Planning & Urban Development Department

TO: Zoning Board of Appeals Chair and Members

SUBJECT: 142 East Kidder Street – 169-E-028 & 029

DATE: January 21, 2015

Exhibit B

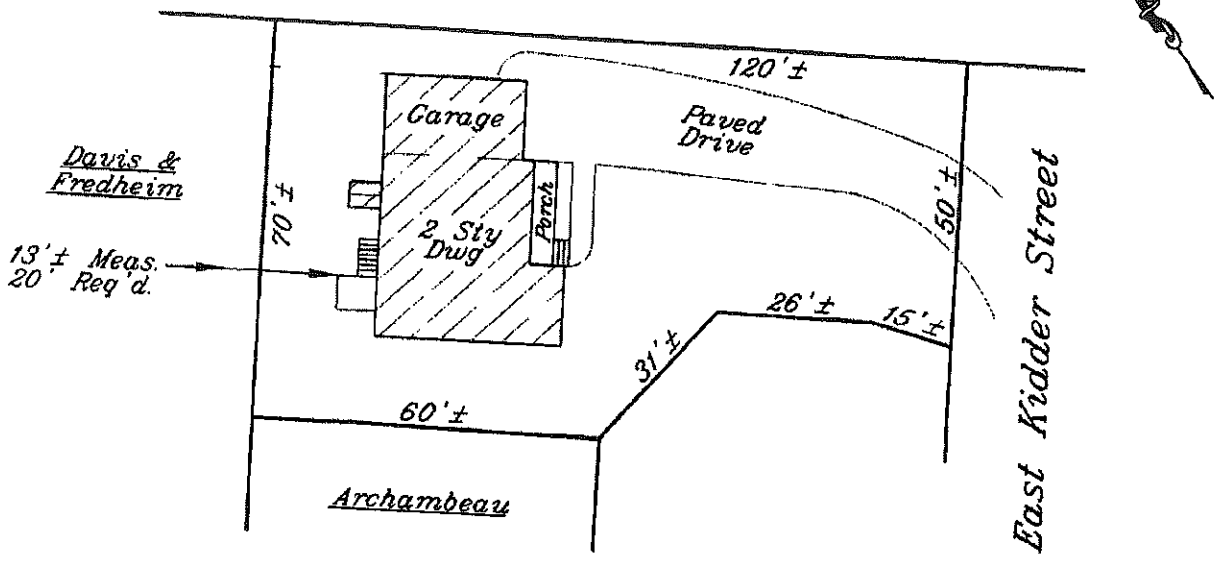
When Lincoln Capital submitted the Practical Difficulty Appeal Application on December 22, 2014, one of the documents submitted was the Mortgage Loan Inspection Plan dated 11/21/2014 signed by James Nadeau of Nadeau Land Surveys (Exhibit D). This plan shows the circled, 19.4 +/- Meas. with an arrow to the corner of the garage. It also shows the 13' +/- Meas. with an arrow to the corner of the deck. This plan is the same plan that was sent to George Froehlich on 12/4/14 but the 19.4 +/- meas. was not shown on the plan that George received (Exhibit B). George Froehlich issued the Certificate of Occupancy based on the Exhibit B plan. He revoked the Certificate of Occupancy on 1/9/15.

Revised First Floor Plan - Garage

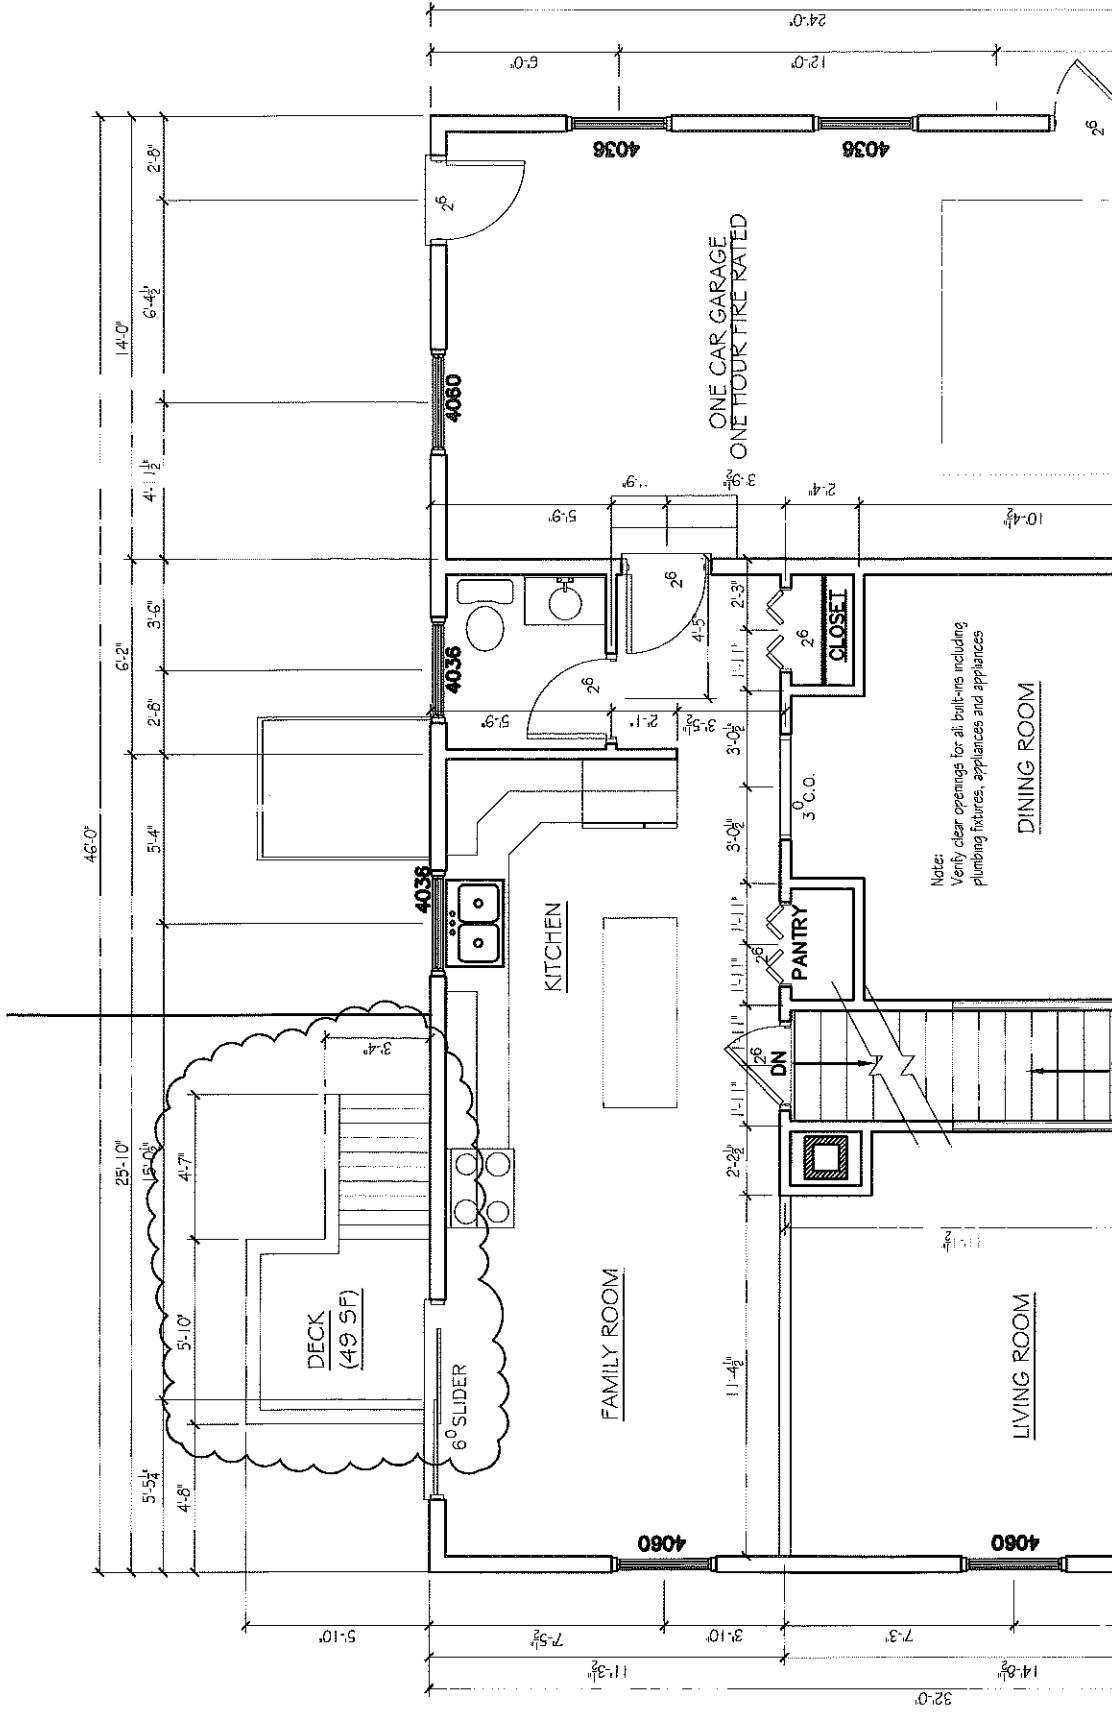
were provided on the Plan, it is 13' to the deck and according to the Revised First Floor Plan for the deck (Exhibit C) the deck is 5'10" deep so the setback to the rear of the house would be 18'10". The required setback is 20' [section 14-(a)(4)(b)].

Exhibit D

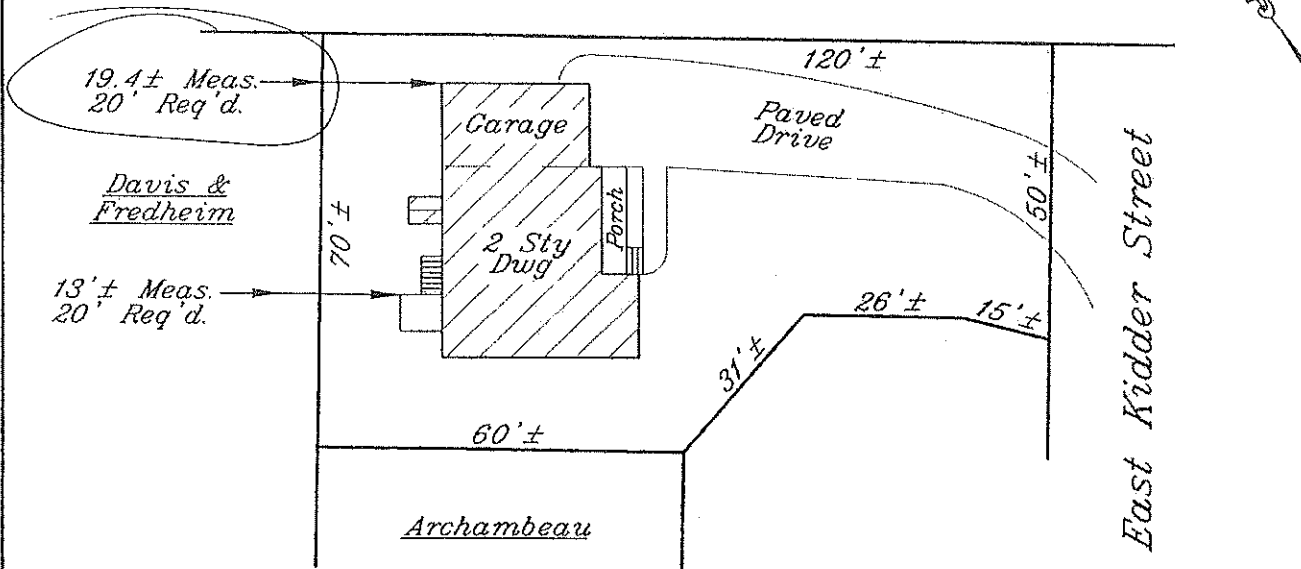
I spoke to James Nadeau on January 20, 2014. He confirmed that the Mortgage Loan Inspection Plan that was done on 11/21/14 and signed by him on 11-25-14 had both the 19.4 measurement and the 13' measurement on it. He also said that he had previously done a survey in the area and he is confident in the accuracy of the Plan that he submitted to Preferred Title & Closing. Looking at the dimensions that
